Subject: FW: OBJECTION - AB/49/20/L

Subject: OBJECTION - AB/49/20/L

Further to my original objection I am now writing to express my concerns that new plans and designs have since been submitted outside of the consultation window.

Proposed Ground Floor Plan
(Showing structure over)
(1:50)

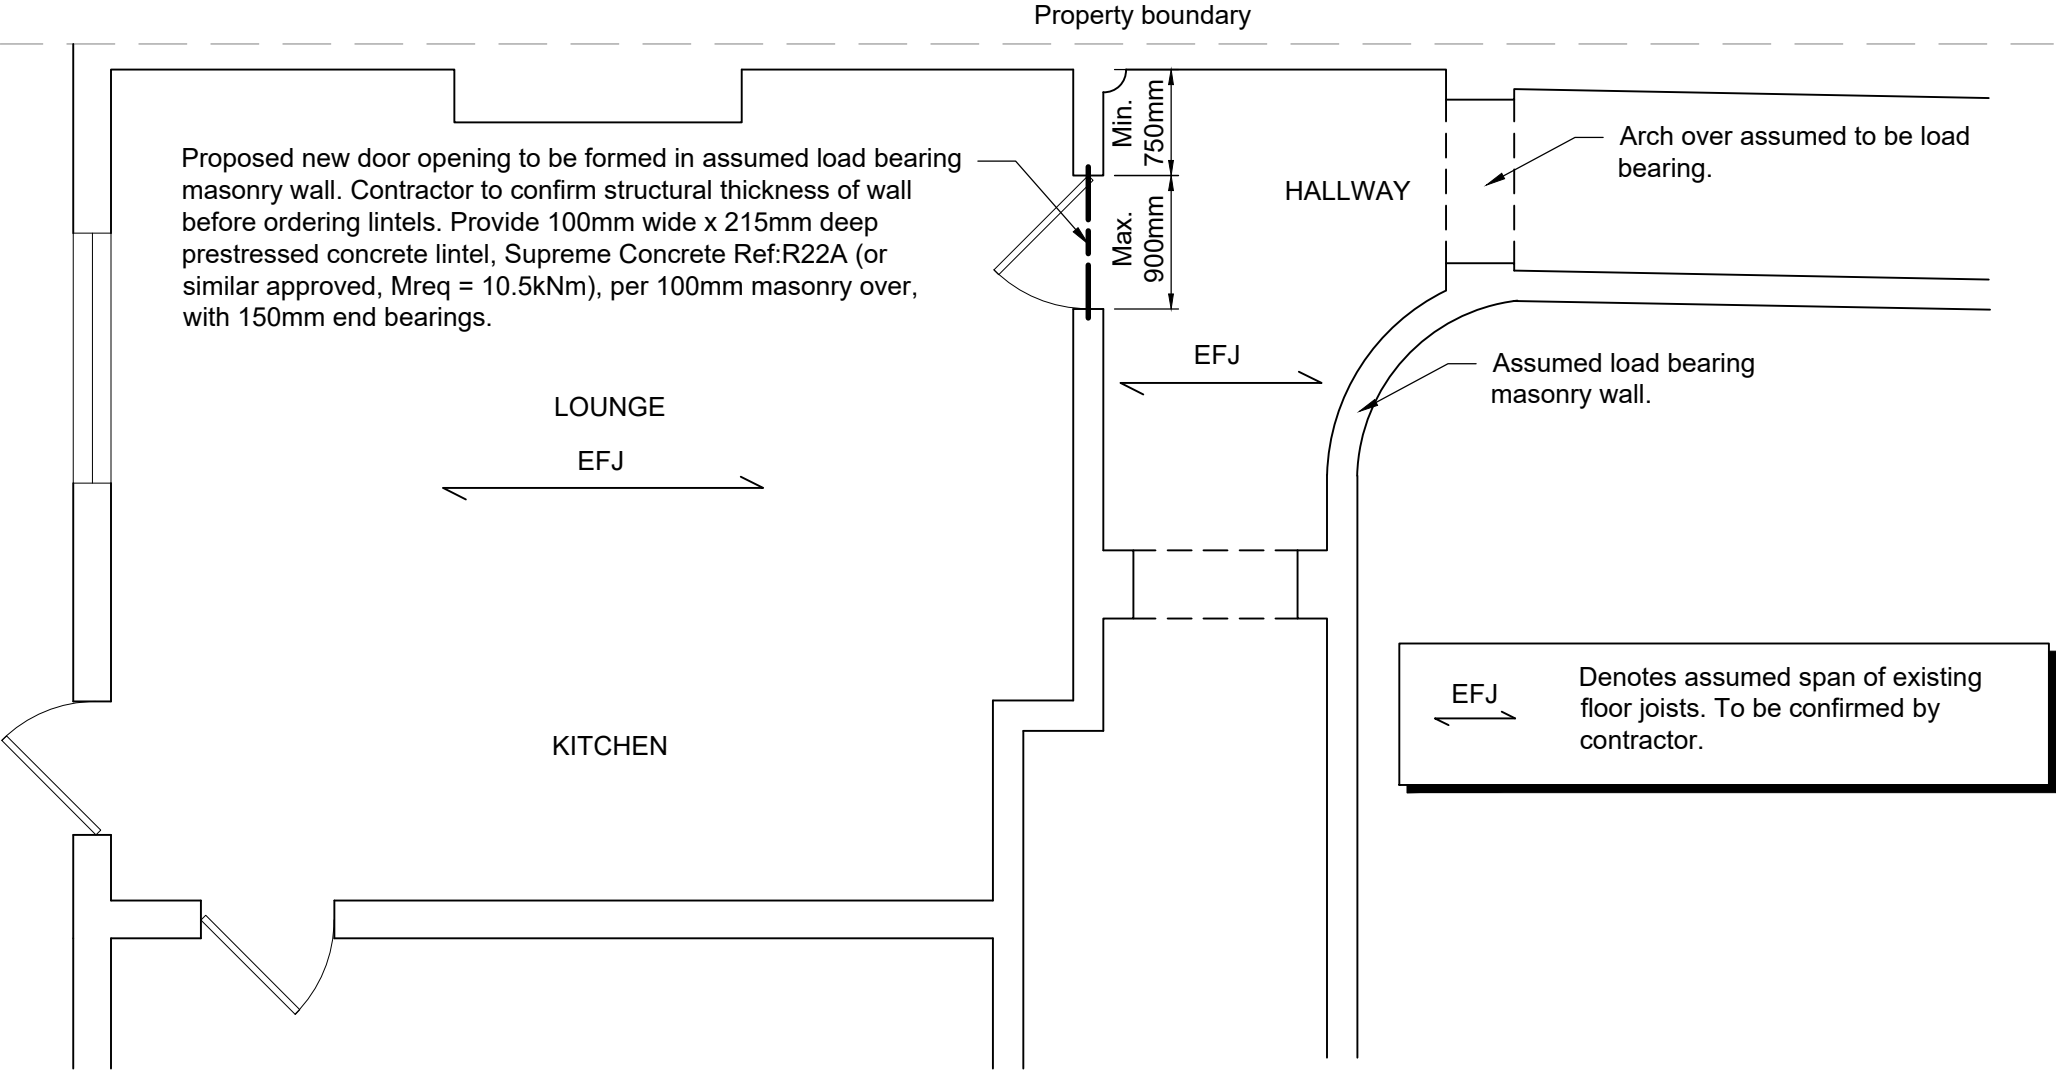
Following Martyn White's comments regarding destroying the further fabric of building, and the need for a full structural engineers assessment, it is noted that the current structural engineer report has made a fundamental incorrect assumption about the wall being continuous to roof level. It has already been knocked through at my level (2nd Floor) and also below me, and there has been no assessment to see if the necessary structural supports were added.
